Project Number: 2019-002639

200 Lomas NW

SUBJECT: Sketch

200 LOMAS ALBUQUERQUE, NM	DRAWN BY AS
	SIDEWALK VARIANCE EXHIBIT	DATE 06-04-2025
	TIERRA WEST, LLC 5571 MIDWAY PARK PLACE NE ALBUQUERQUE, NM 87109 (505) 858-3100 www.tierrawestllc.com	SHEET # EX-1
		JOB # 2025015

06/04/2025 RONALD R. BOHANNAN P.E. #7868	200 LOMAS ALBUQUERQUE, NM SIDEWALK VARIANCE EXHIBIT	DRAWN BY AS DATE 06-04-2025
	 TIERRA WEST, LLC 5571 MIDWAY PARK PLACE NE ALBUQUERQUE, NM 87109 (505) 858-3100 www.tierrawestllc.com	SHEET # EX-1 JOB # 2025015

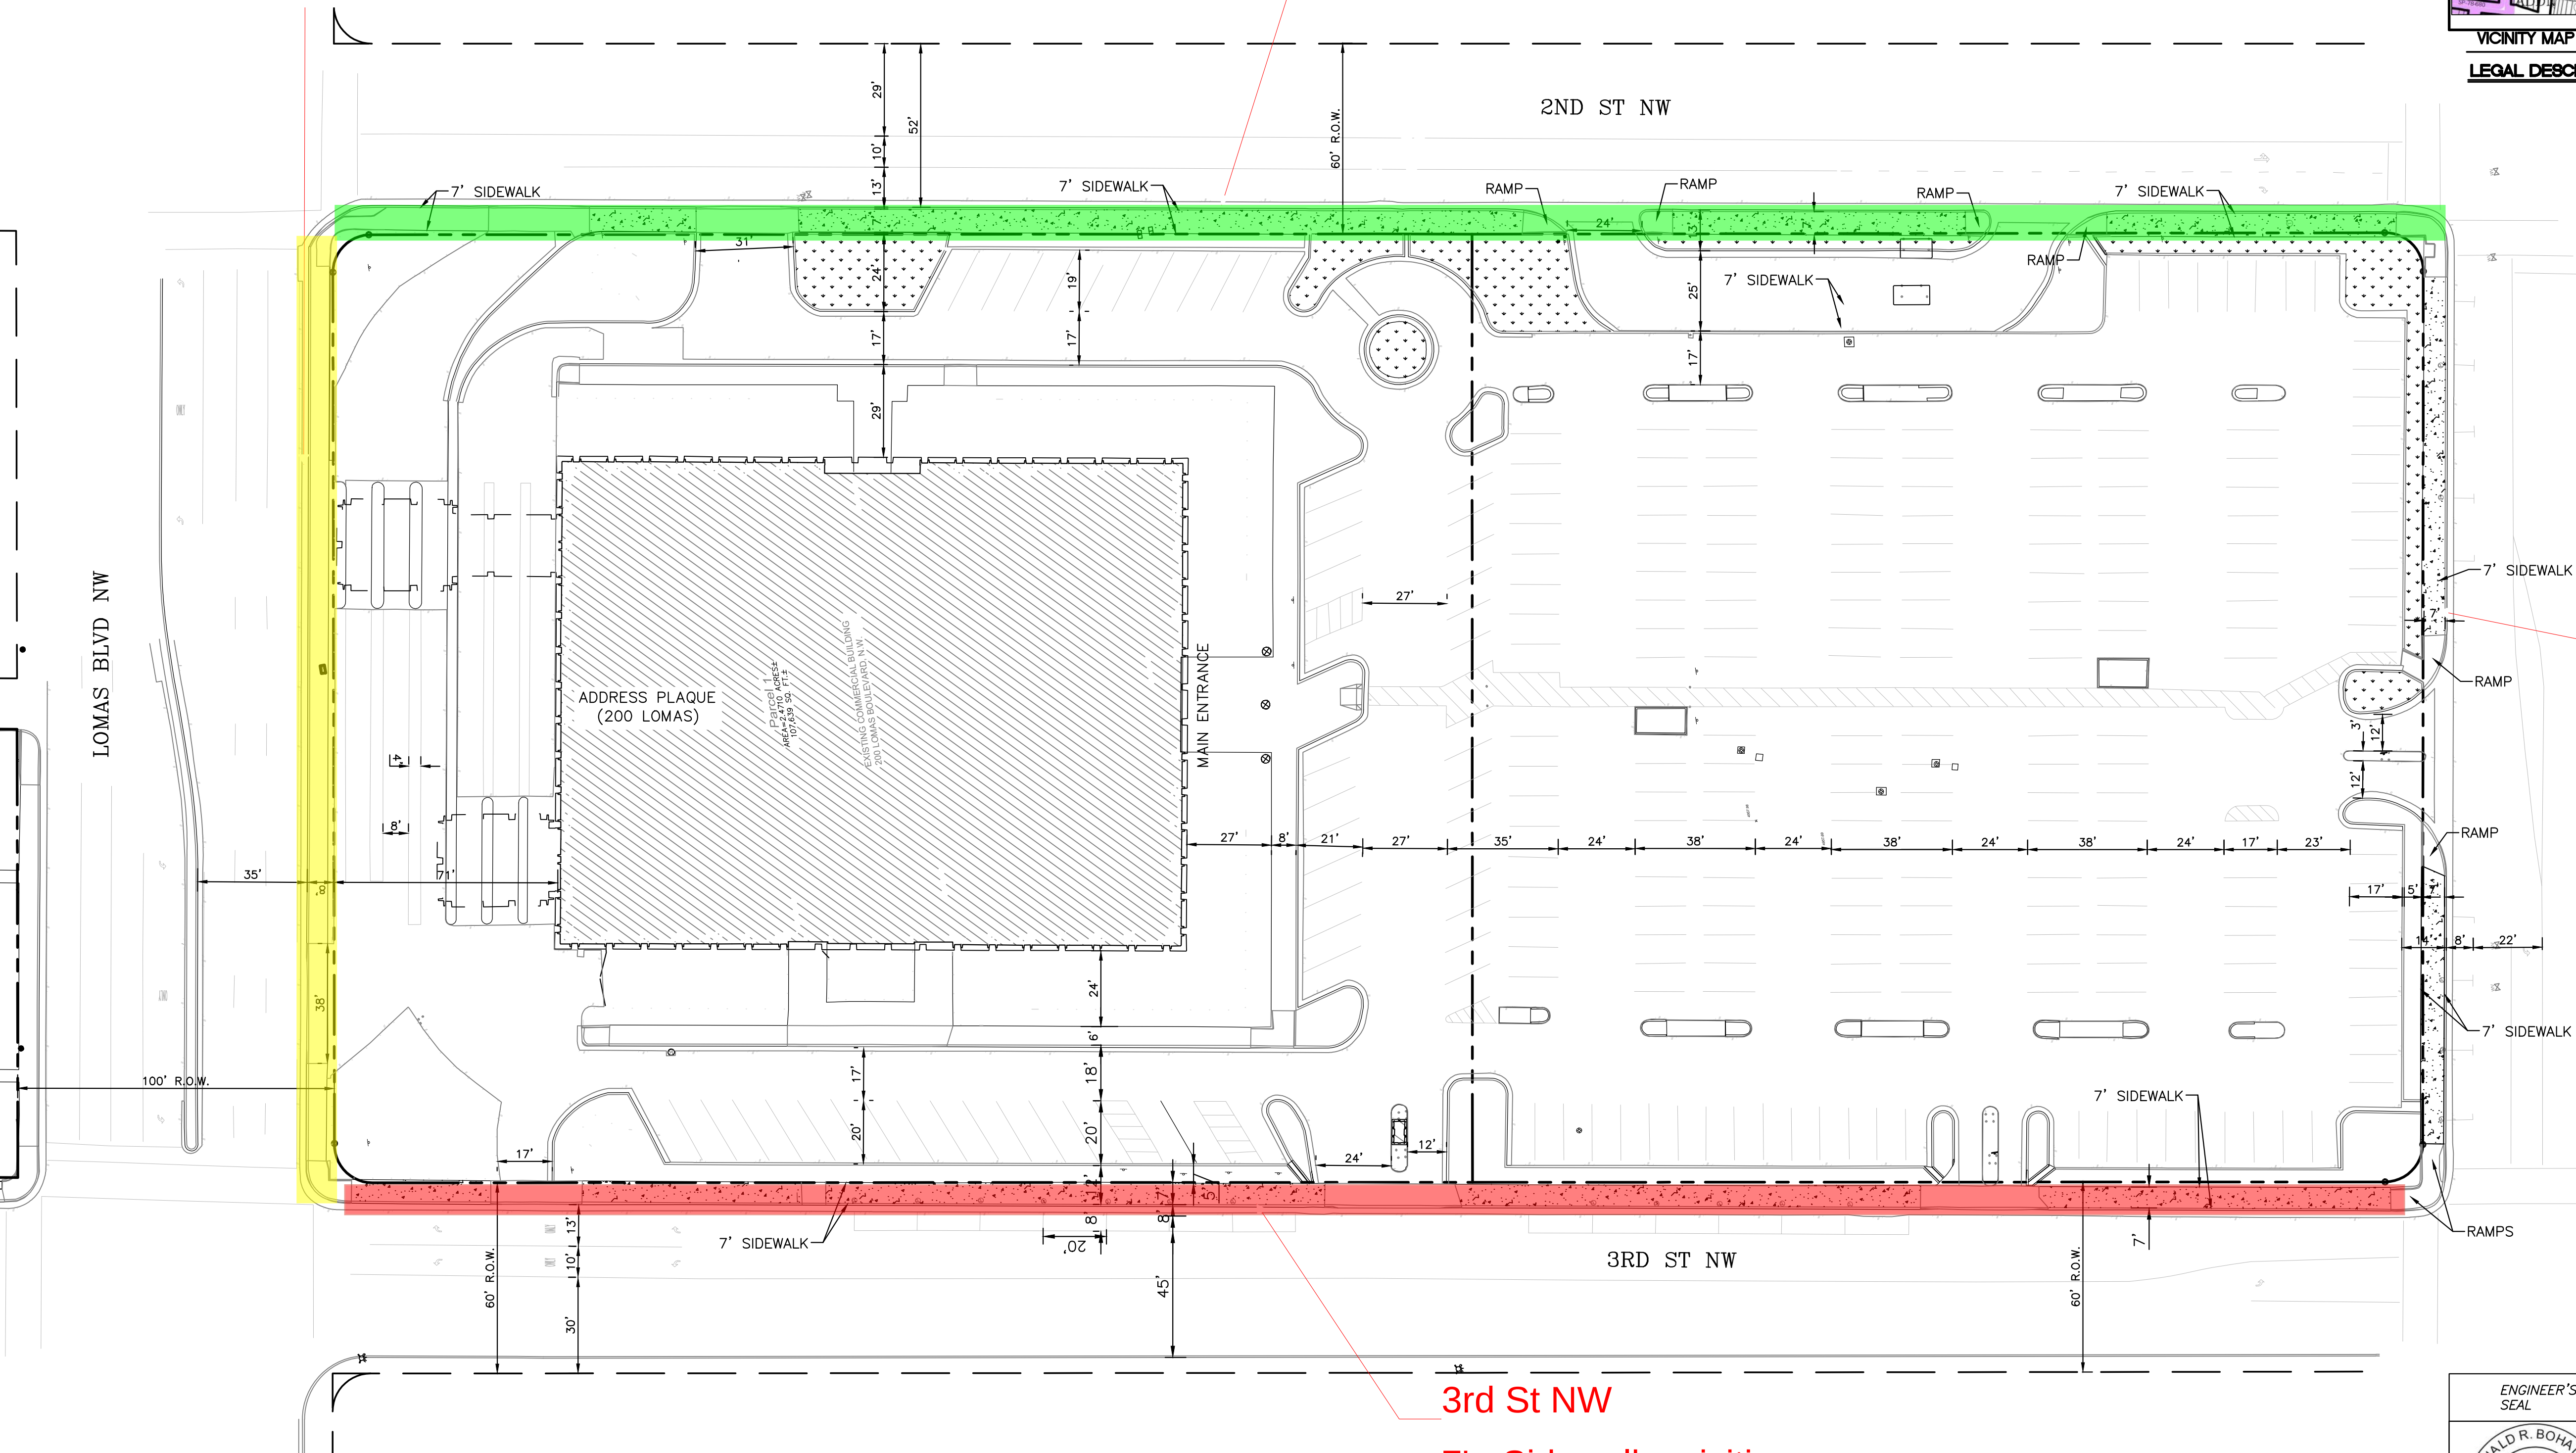
1. Lomas, 2nd, and 3rd are Principal arterial require 10' sidewalks and 6'-8' landscaping buffer. Existing widths are 7' along 2nd and 3rd, 8' along Lomas, require to be widened to 10'.
2. Roma is local road requires 5' sidewalk and 4'-6' landscaping buffer, the existing 7' sidewalk is in compliance.
3. Any future development will require an approved TCL prior to site plan or building permit. Also, a Traffic Scoping Form would need to be submitted to determine if a TIS would be required.

7' - Sidewalk existing
10' sidewalk and 6'-8' landscape
buffer required.

7' - Sidewalk existing
10' sidewalk and 6'-8' landscape
buffer required.

7' - Sidewalk existing
10' sidewalk and 6'-8' landscape
buffer required.

- **Lomas Blvd** – Existing width: **7'-0"** → **Requested waiver: 3'-0"**
- **2nd Street** – Existing width: **7'-0"** → **Requested waiver: 3'-0"**
- **3rd Street** – Existing width: **7'-0"** → **Requested waiver: 3'-0"**

(3)Waiver for sidewalk on Lomas/2nd st/3rd St at 200 Lomas from IDO subsection 5-3(D) referring to the DPM requiring sidewalk to be 10'-0"; sidewalk is currently 7'-0". Asking for a waiver of 3'-0".
